To: Kelly Bacon, Planner 1  
From: Holly Erdman, Environmental Health Specialist  
Date: September 30, 2020  
Subject: CU-20-00003 Carey

# Site Plan

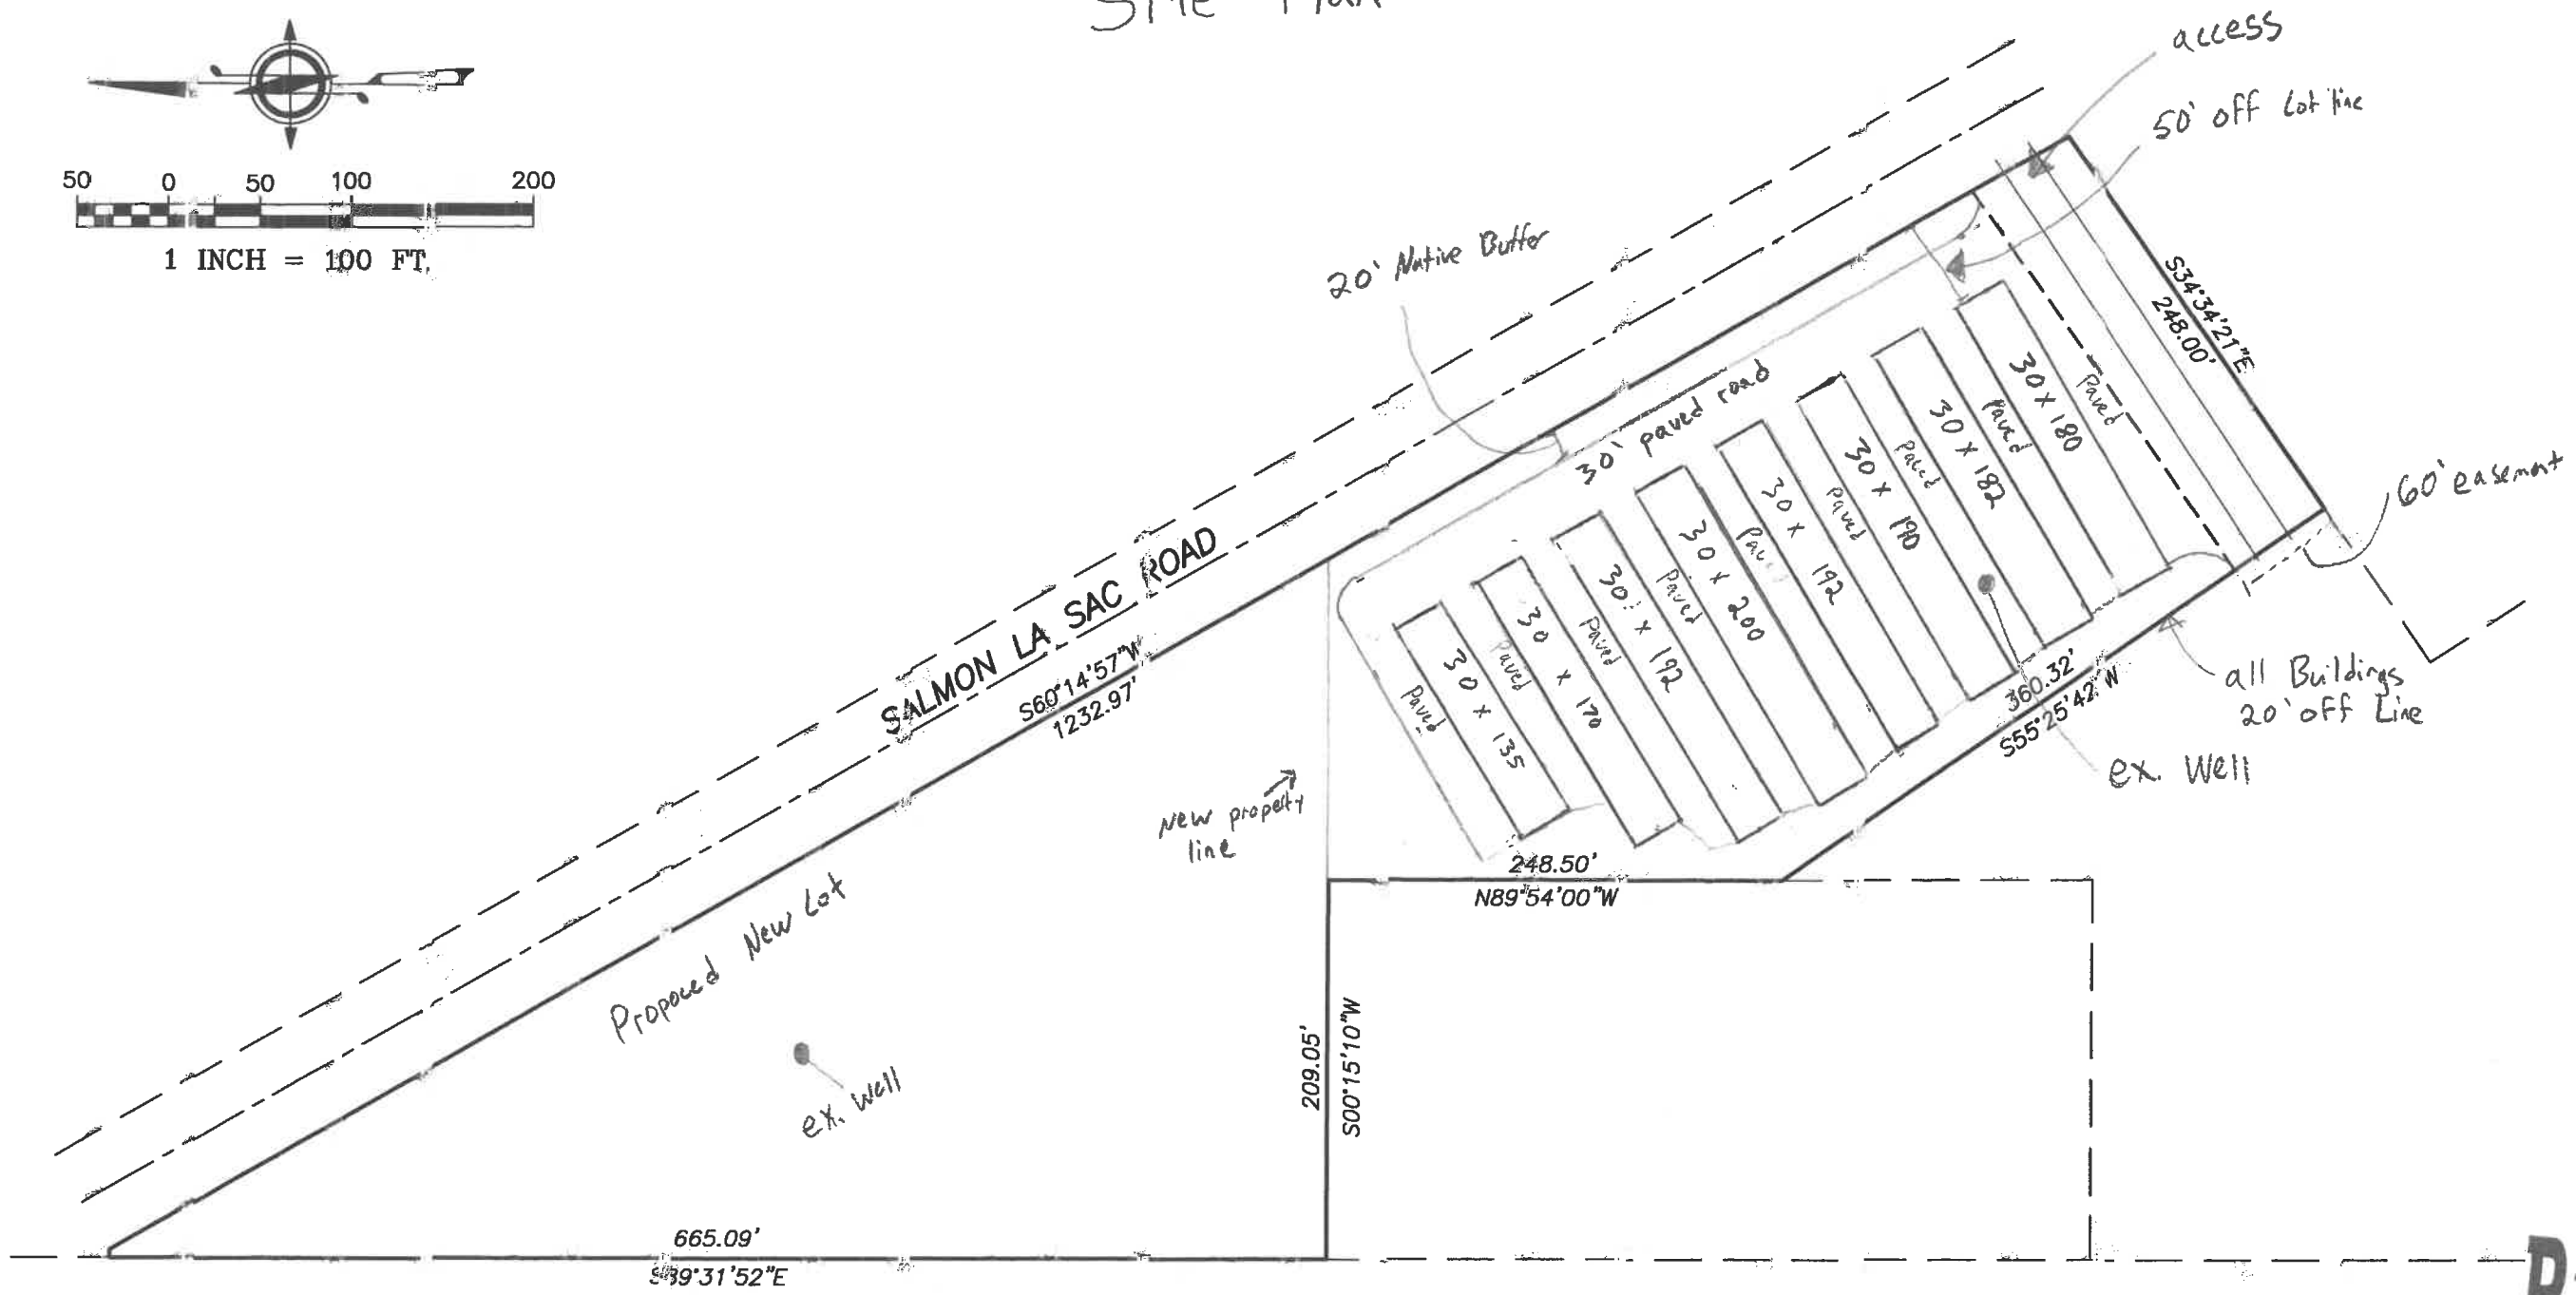
Thank you for the opportunity to comment on the Carey application regarding water and septic requirements to comply with Kittitas County Public Health Department's Environmental Health requirements. The project site plan indicates that there are two existing wells on the parcel, but it is unclear how water will be put to use in a structure. This additional information is needed to enable Environmental Health to do a complete review of this project.
